# CITY OF ALBUQUERQUE

**Re: Burger King**  
**5508 4<sup>th</sup> St NW**  
**Request for Certificate of Occupancy**  
**Transportation Development Final Inspection**  
Architect's Stamp dated 02-22-18 (F14-D055)  
Certification dated 11-19-18

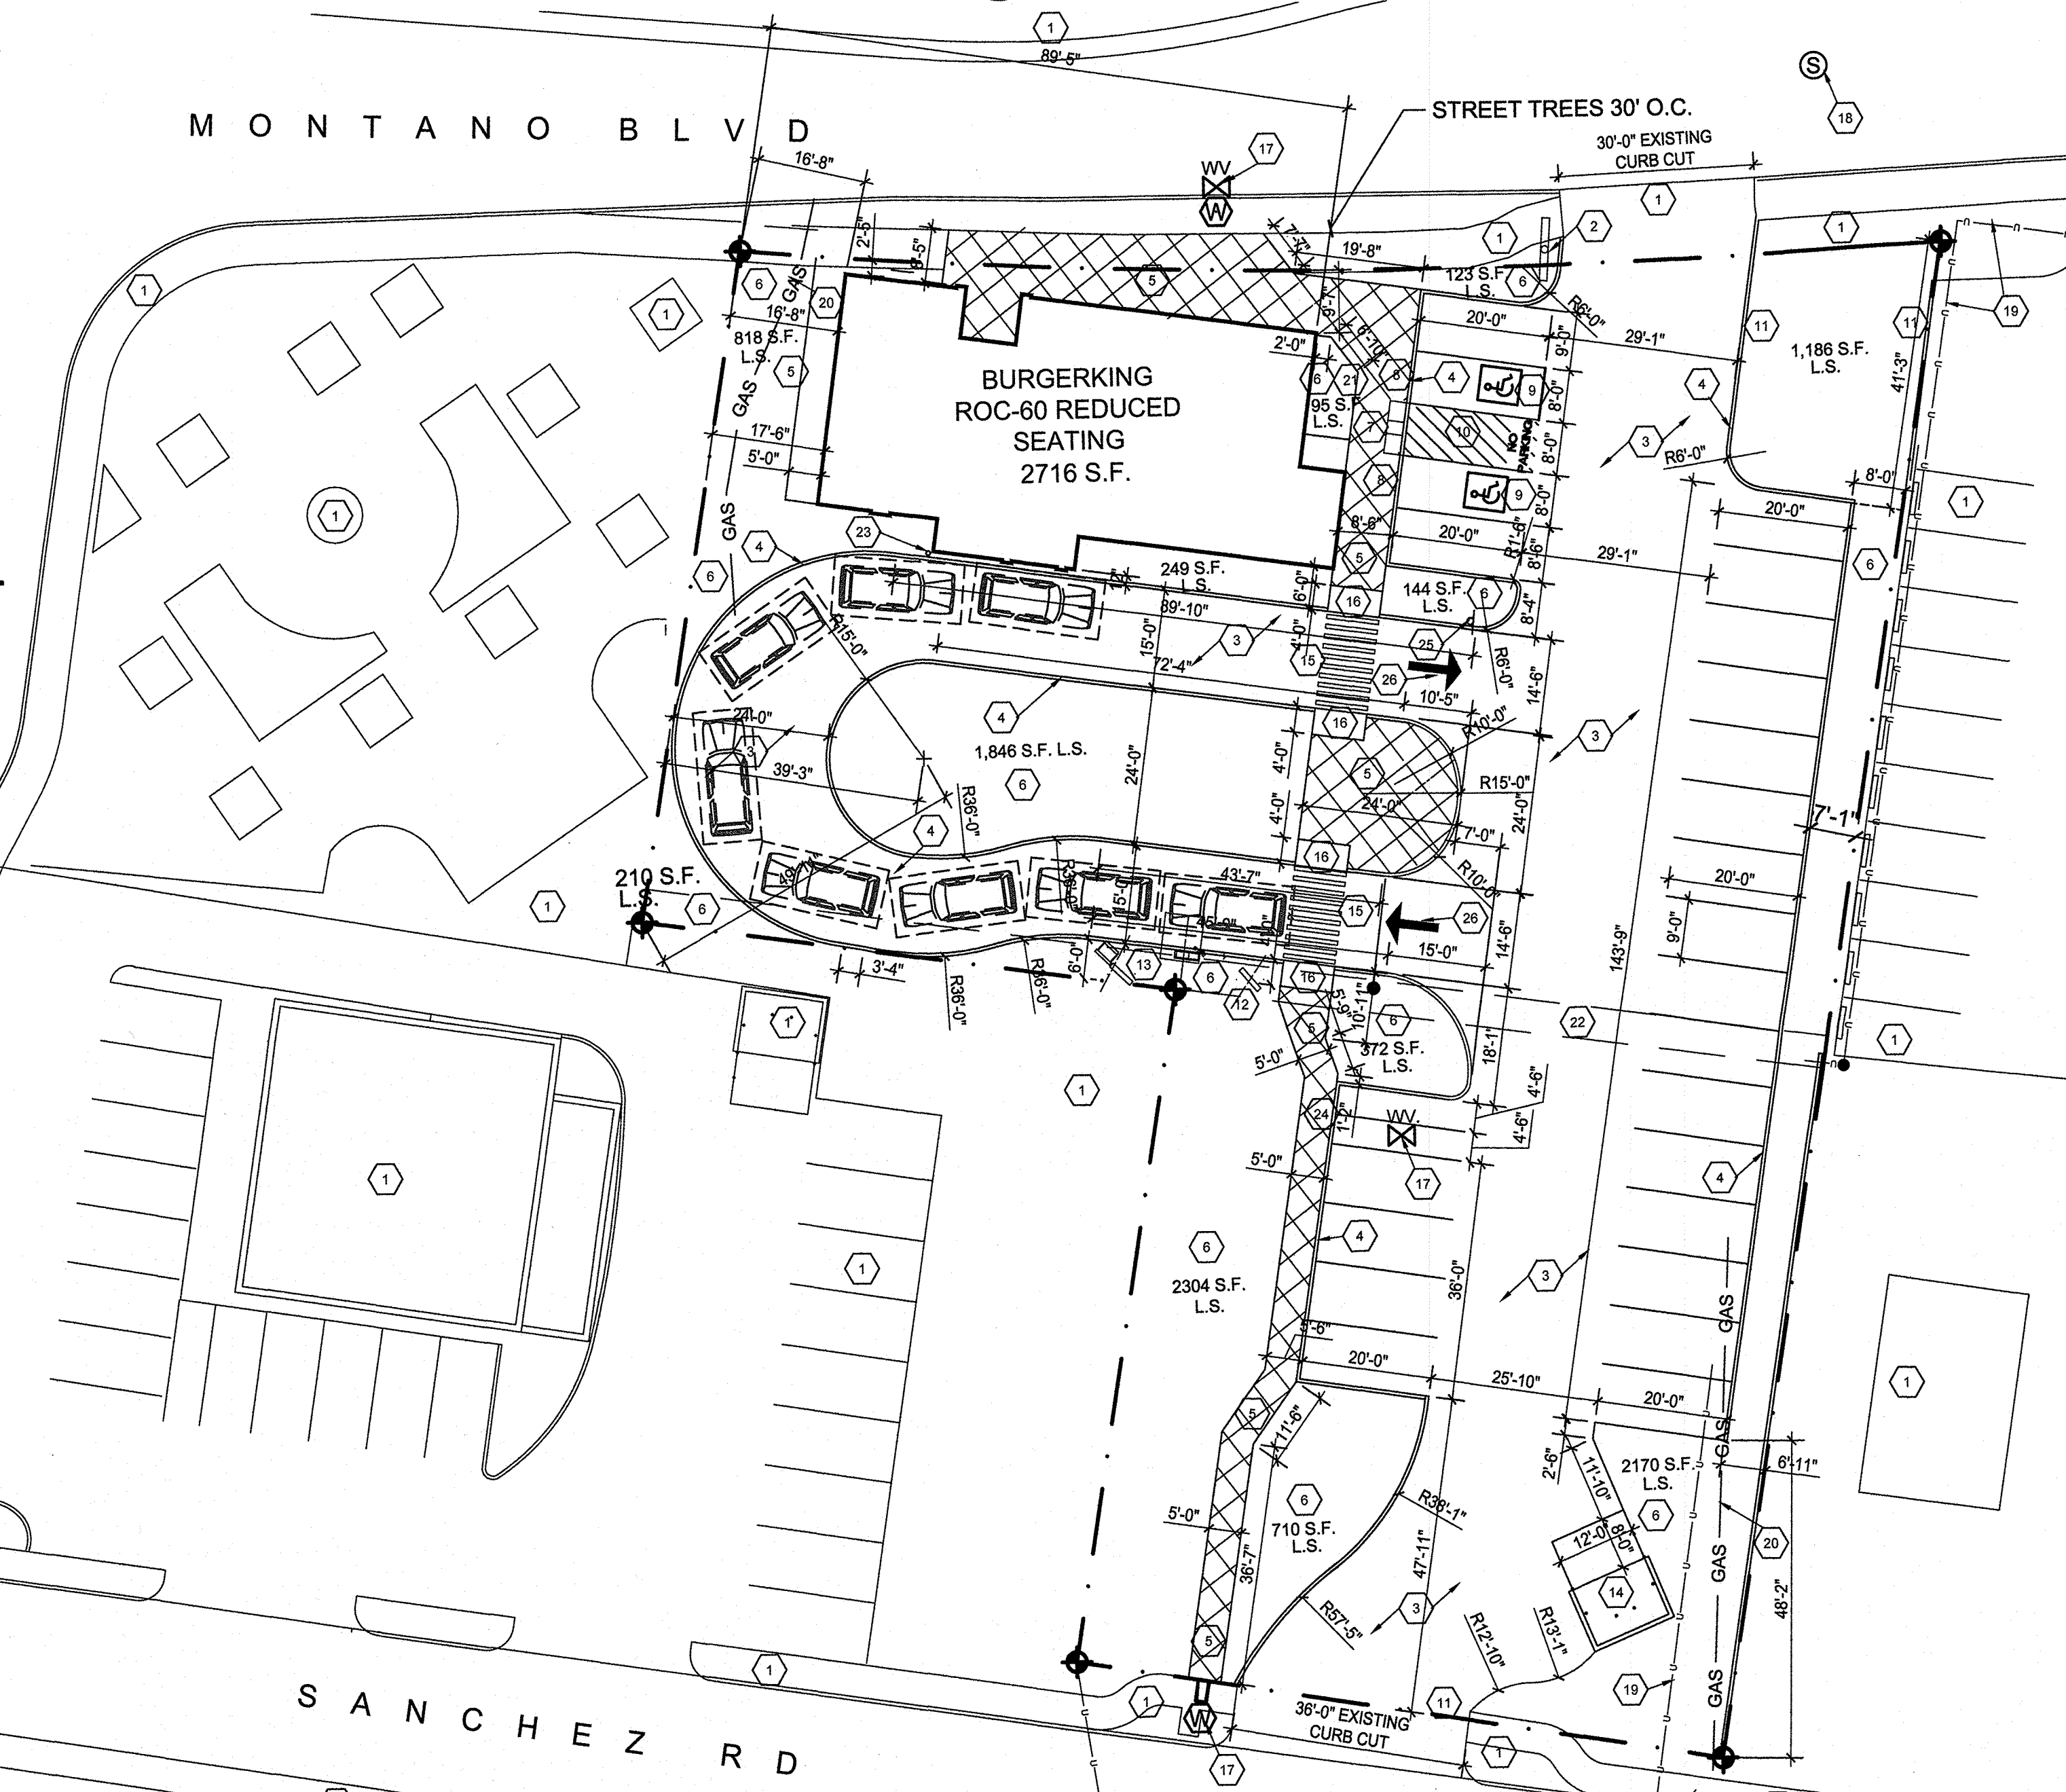
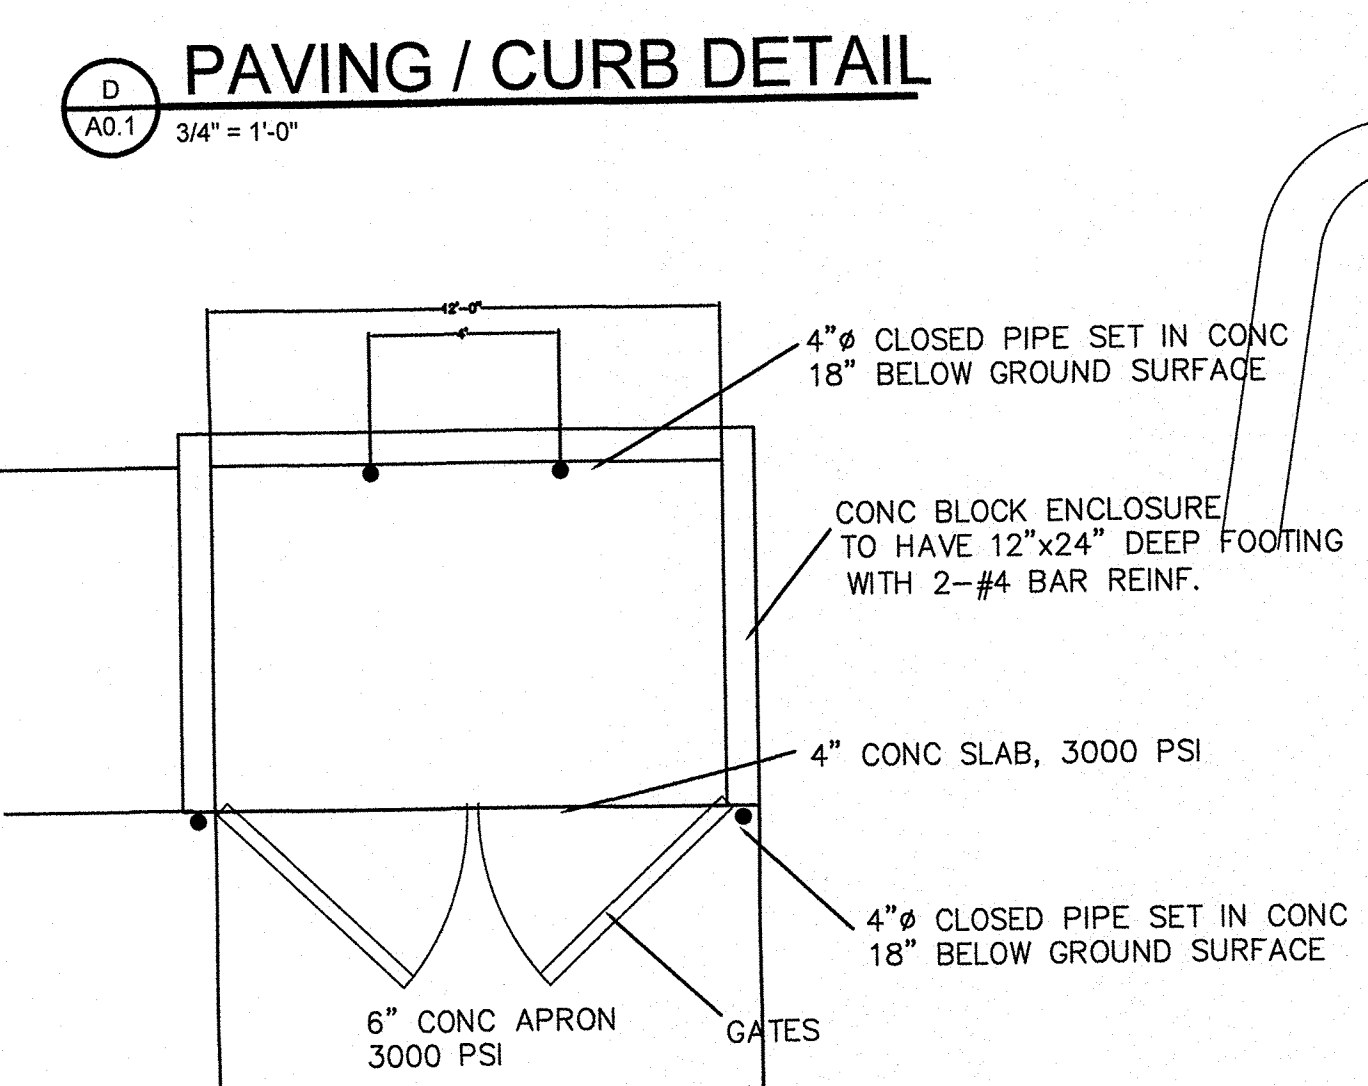
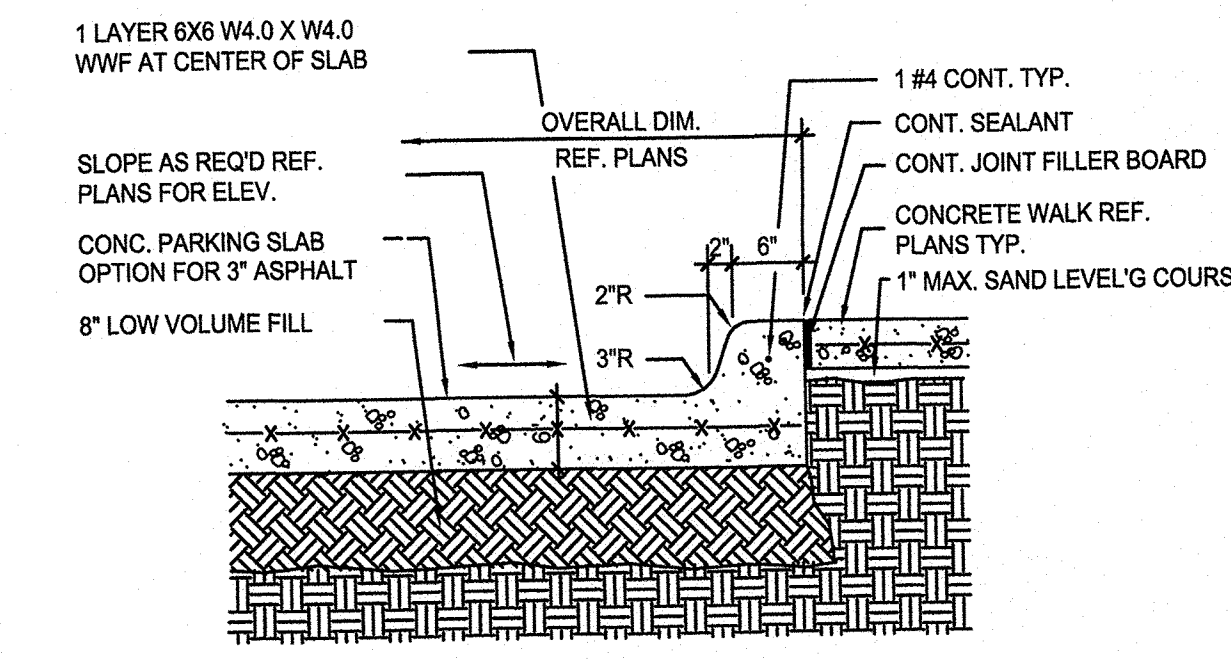
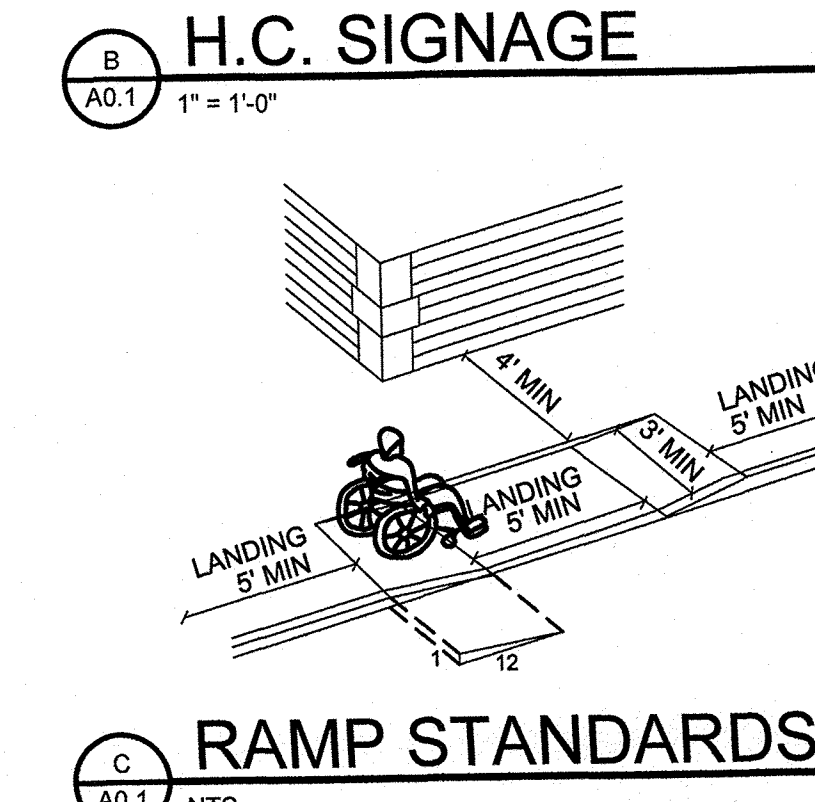
1. Please remove all construction debris and equipment.
2. Remove security fence.
3. Add motorcycle sign.
4. Add bicycle rack.
